From: Paul Cann <Paul.Cann@arun.gov.uk>
Sent: 11 September 2025 14:24
To: Planning.Responses <Planning.Responses@arun.gov.uk>
Cc: Sarah Burrow <Sarah.Burrow@arun.gov.uk>; Amber Willard <Amber.Willard@arun.gov.uk>
Subject: RE: Planning Consultation on: Y/15/25/PL

Consultation response in respect to surface water drainage:

Application No: Y/15/25/PL

Site Address: Stakers Farm North End Road Yapton BN18 0DU

TITLE
Proposed Drainage and Levels Layout Plan

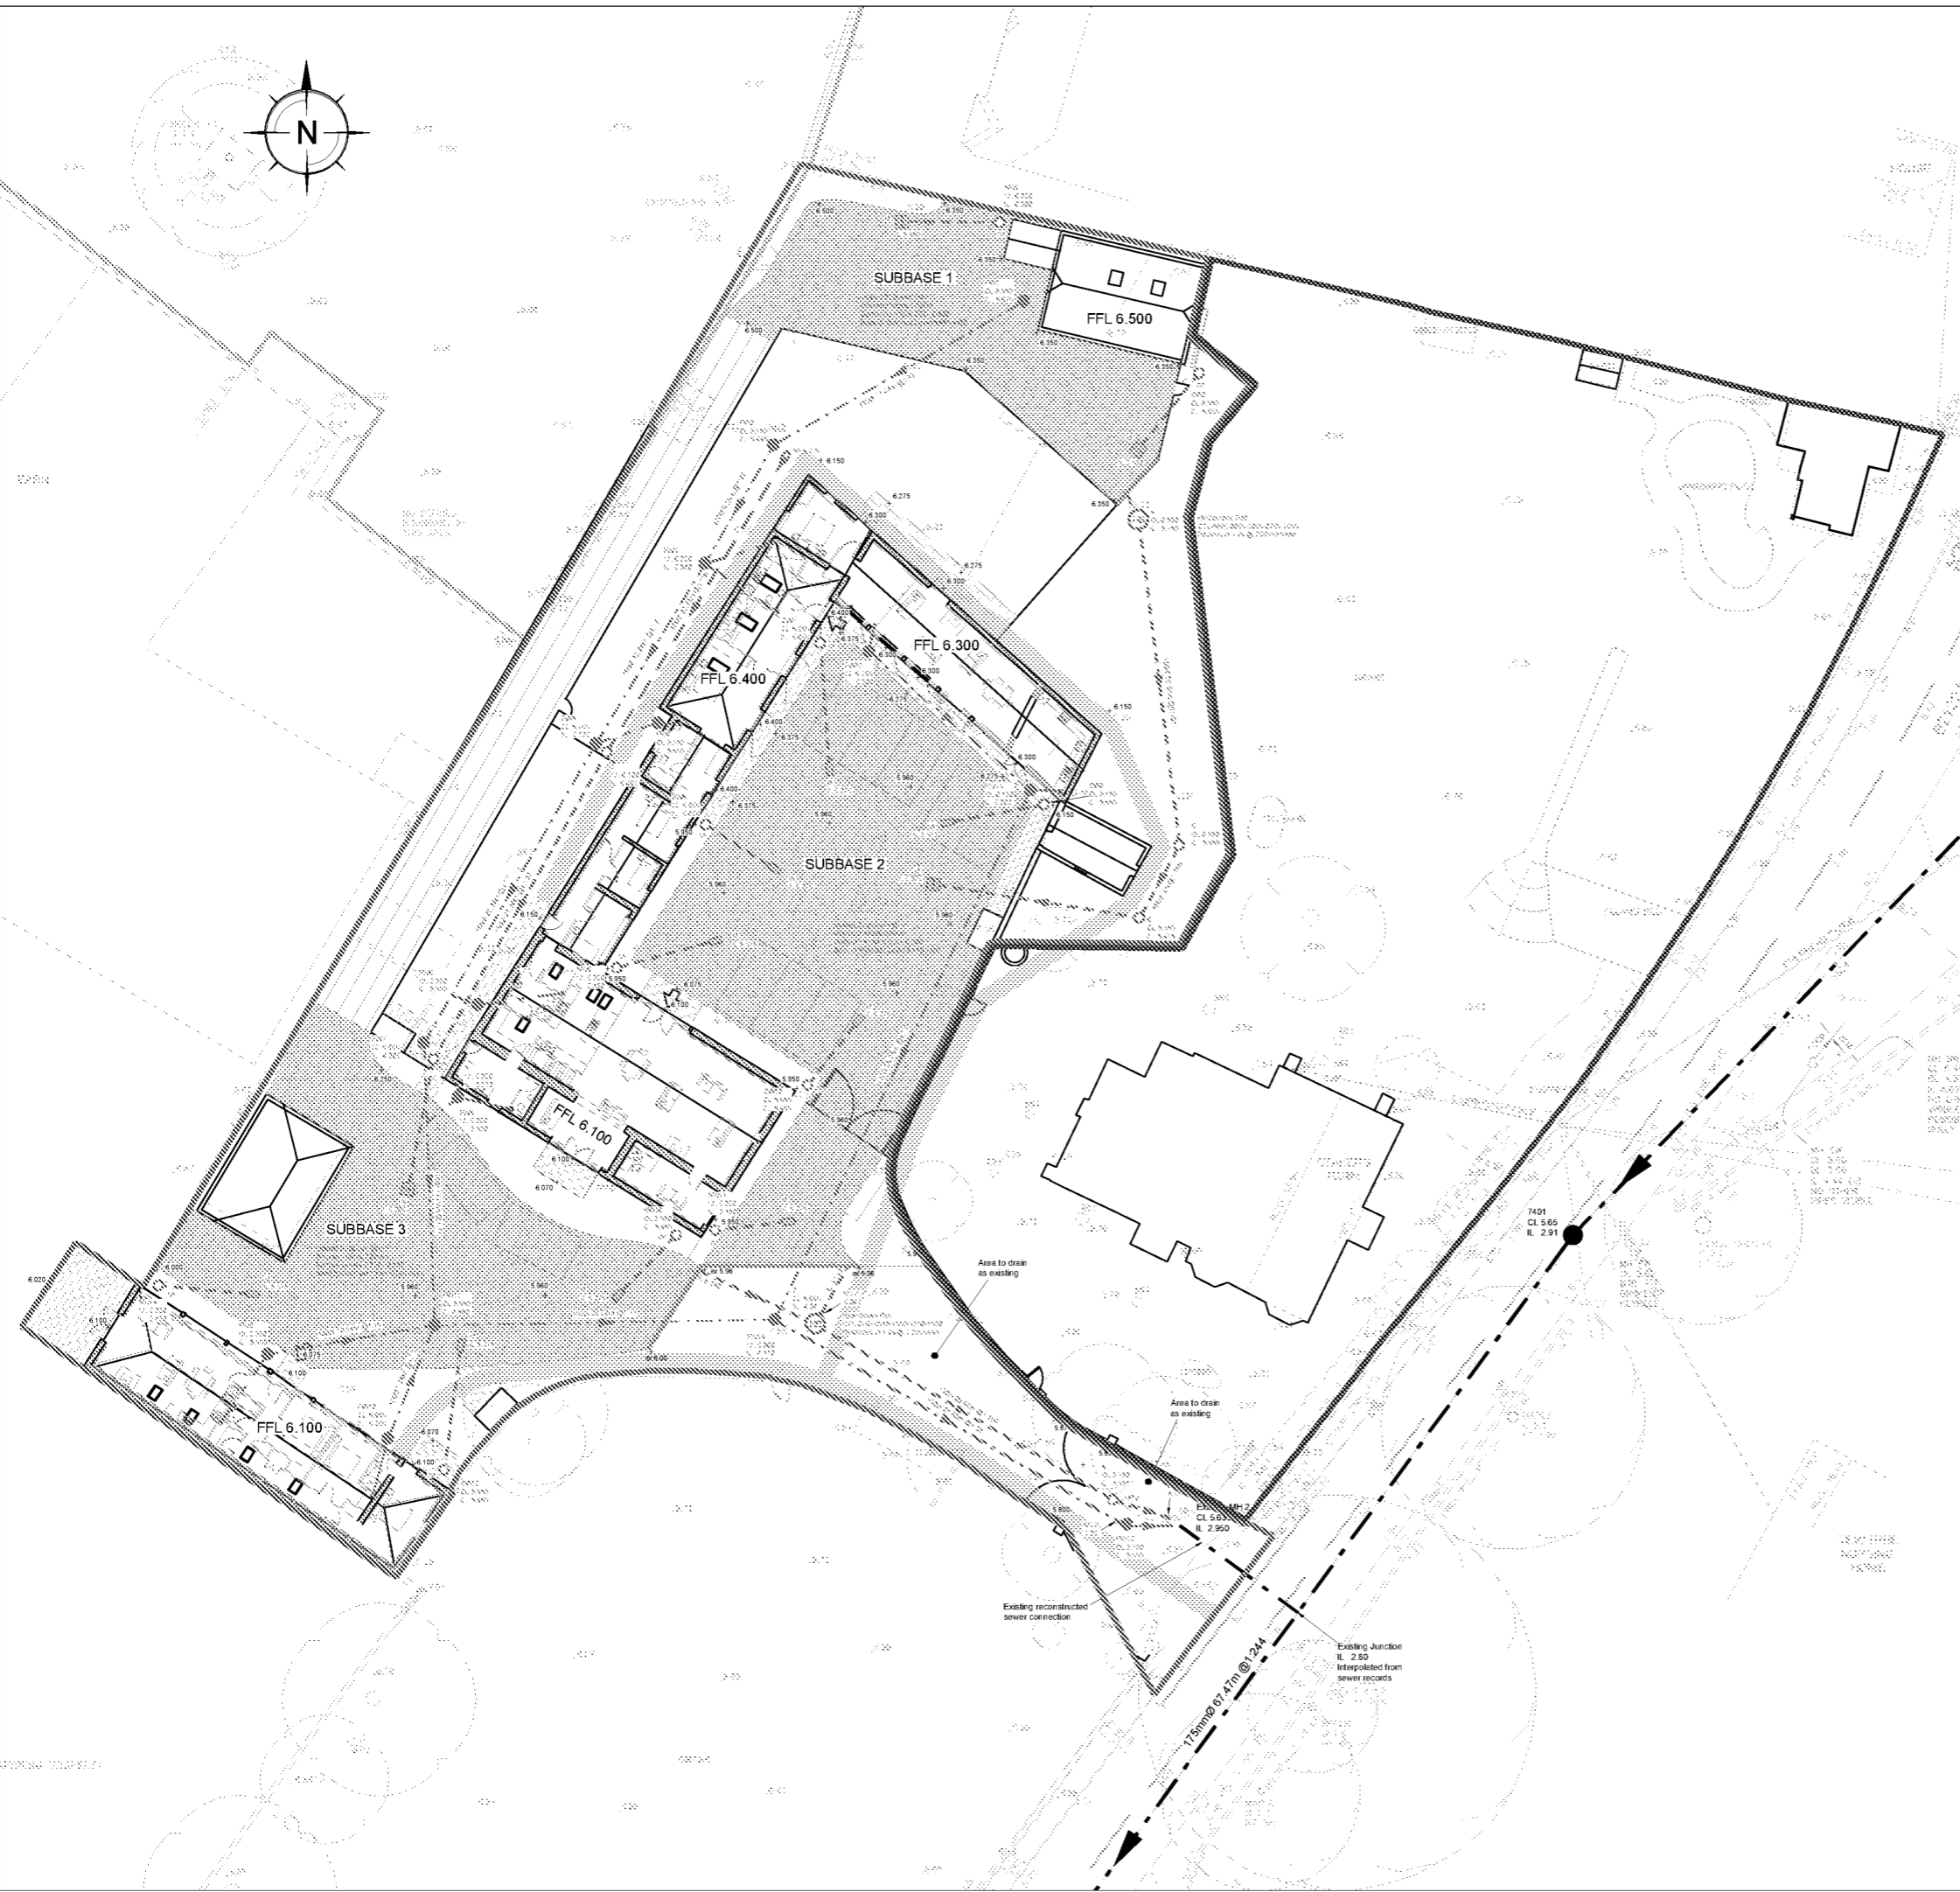
1. The applicant's attention is also drawn to a recent Planning Appeal at the Windmill Inn, Mill Lane, Rustington (APP/C3810/W/25/3361225) which references existing/proposed surface water connections to foul only sewers. The appeal was dismissed for reasons that can be related to aspects of this proposed development.
2. Essentially, connection of surface water to foul only sewers is not a consideration within the hierarchy of surface water disposal options as specified in 'STANDARD 1; runoff destinations' of the National Standard for SuDS (NSfS) - extract below;

1.2 Runoff from the development shall be discharged to the following final destinations, to the maximum extent practicable, in accordance with the below hierarchy:

- priority 1: collected for non-potable use
- priority 2: infiltrated to ground
- priority 3: discharged to an above ground surface water body
- priority 4: discharged to a surface water sewer, or another piped surface water drainage system
- priority 5: discharged to a combined sewer

Note 2: for the purposes of this standard, a combined sewer is a sewer intended to receive both foul sewage and surface runoff and does not include a sewer intended to receive only foul sewage, even if it has the capacity to accommodate additional flows or has an element of surface water in it already.

The fact that surface water from the site currently connects to the foul sewer system is irrelevant when considering the hierarchy. Also, reducing flow rates to the sewer does not necessarily mean an improvement over the existing situation, as discharge volumes are an equally important consideration, and when taken into account, can result in greater volumes ultimately being discharged to the sewer following redevelopment.

3. The existing sewer system is known to overflow downstream, causing flooding and pollution. This is primarily due to groundwater intrusion, surface water inundation and direct surface water connections, overloading a sewer designed for foul waste only.

4. Due to the fact that our primary objection is due to the surface water disposal location and the likely redesign required to achieve an acceptable solution, no other aspects of the surface water drainage design have been considered or appraised in terms of compliance with the NSfS or other criteria. The applicant is urged to fully consider 'STANDARDS' 1 to 7 of the NSfS to ensure all aspects of the design meet the necessary requirements.
